Appeal Decision

Appeal Ref: APP/R5510/D/24/3354748

87 Wimborne Avenue, Hillingdon, Hayes UB4 0HH

- The appeal is made under section 78 of the Town and Country Planning Act 1990 (as amended) against a refusal to grant planning permission.
- The appeal is made by Mr Jinderpal Hayer against the decision of the Council of the London Borough of Hillingdon.
- The application Ref is 14548/APP/2024/1563.
- The development proposed is a first floor side extension.

Proposed First Floor Plan

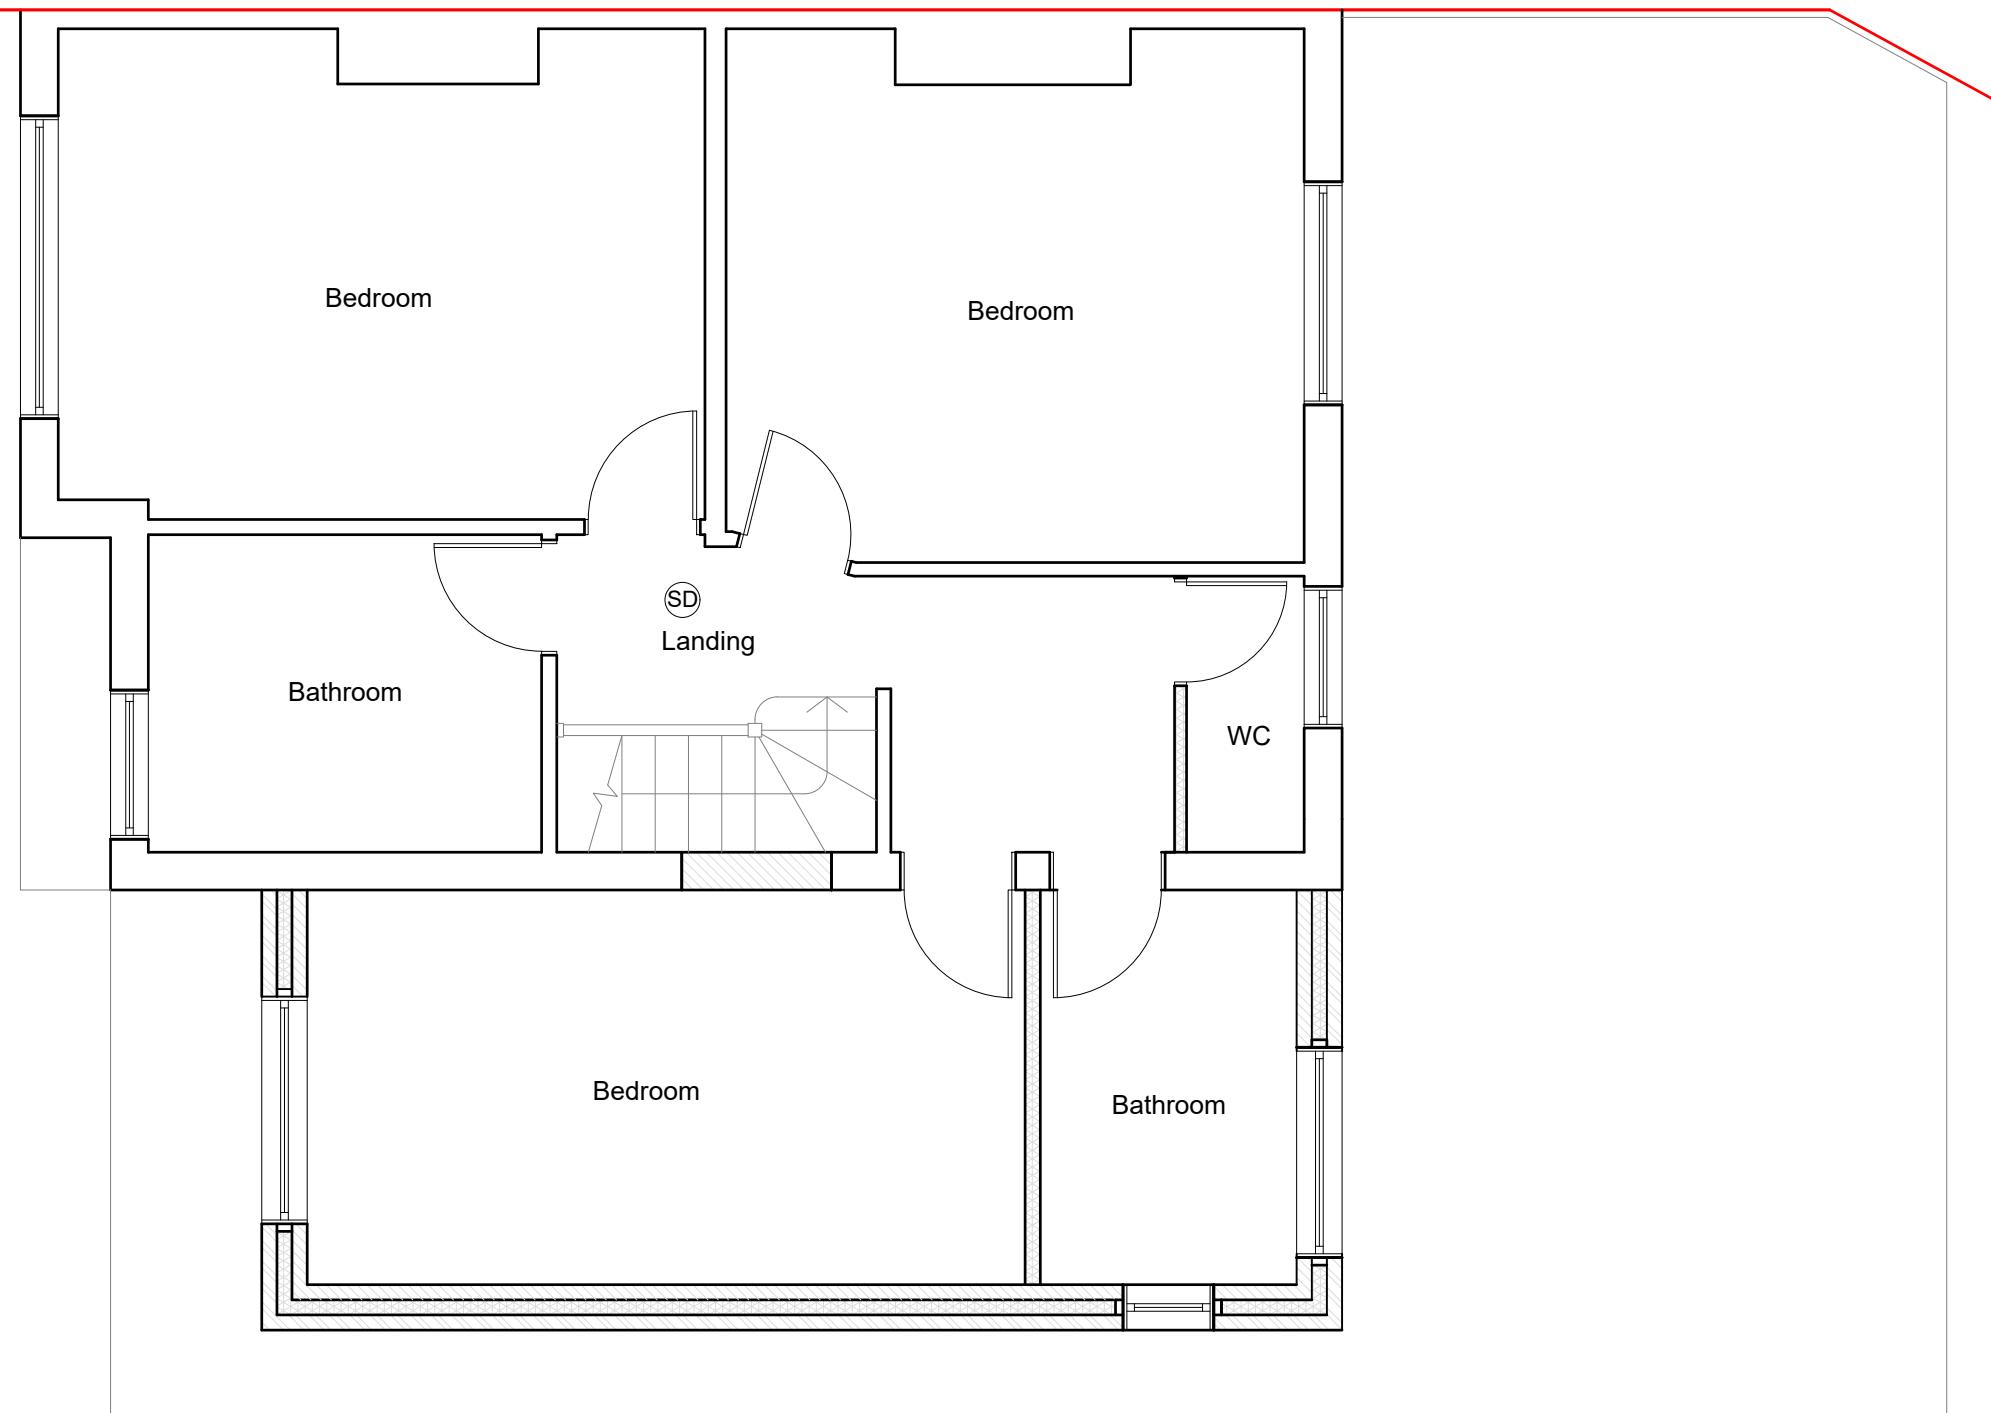
5. The additional bulk of the proposal, in combination with the existing extensions together would not be subordinate to the original dwelling. The cumulative impact of the proposed side extension with the existing, roof and dormer extensions would overwhelm the character of the original property. The result would be that the accumulation of extensions would appear as oppressive and dominant in the context of the existing dwelling. The proposal would therefore visually detract from, and not respect the design of the existing dwelling. Furthermore, considering the

Proposed Front Elevation  
Scale:1:100

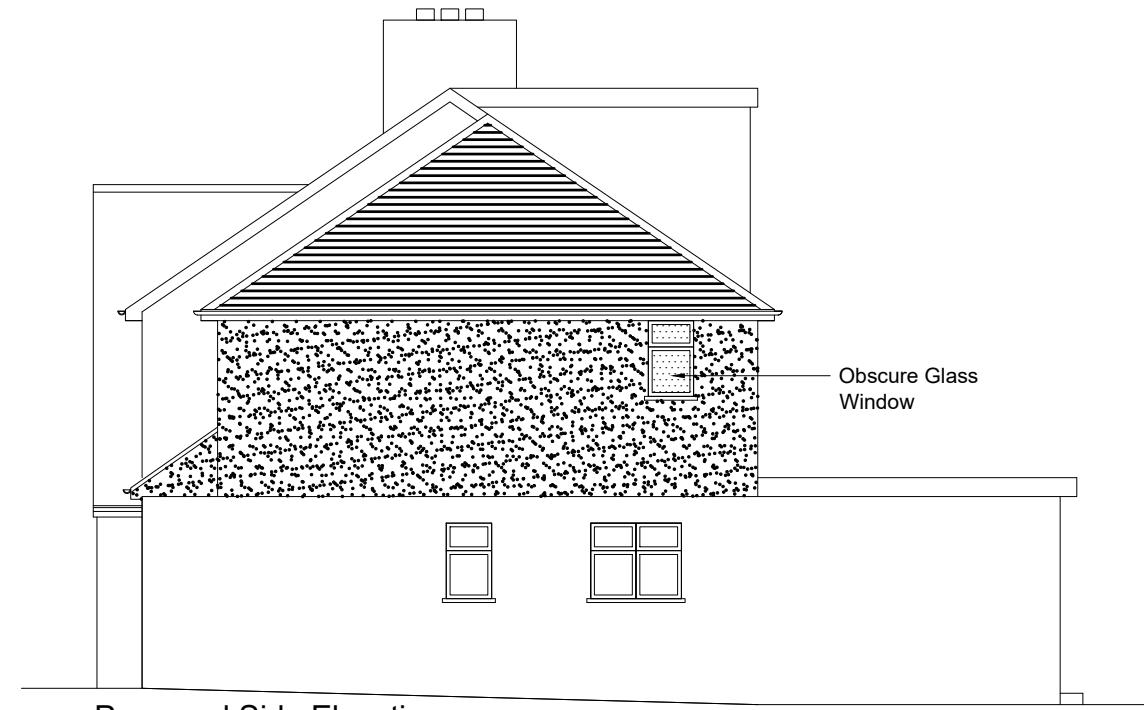
mass and bulk of the adjacent structure, the proposal would appear as disproportionate and would further unbalance the semi-detached pair of properties.

6. Policy DMHD1 Hillingdon Local Plan: Part Two – Development Management Policies 2020 (LP) states that where hip to gable roof extensions exist, a two-storey side extension will not be supported. A combination of both forms of extension would be likely to create a mass that would over-dominate the original form of the dwelling. As such, the proposal would directly conflict with this Policy. Due to the appeal site's position on a corner plot, the proposal would be highly visible from several vantage points. The existing roof, in combination with the proposed roof form would create a disjointed and awkward design. Accordingly the multiple roof forms, including the existing gable roof and dormer and the proposed hip roof form, would be prominent within the street scene and would appear as visually inharmonious.
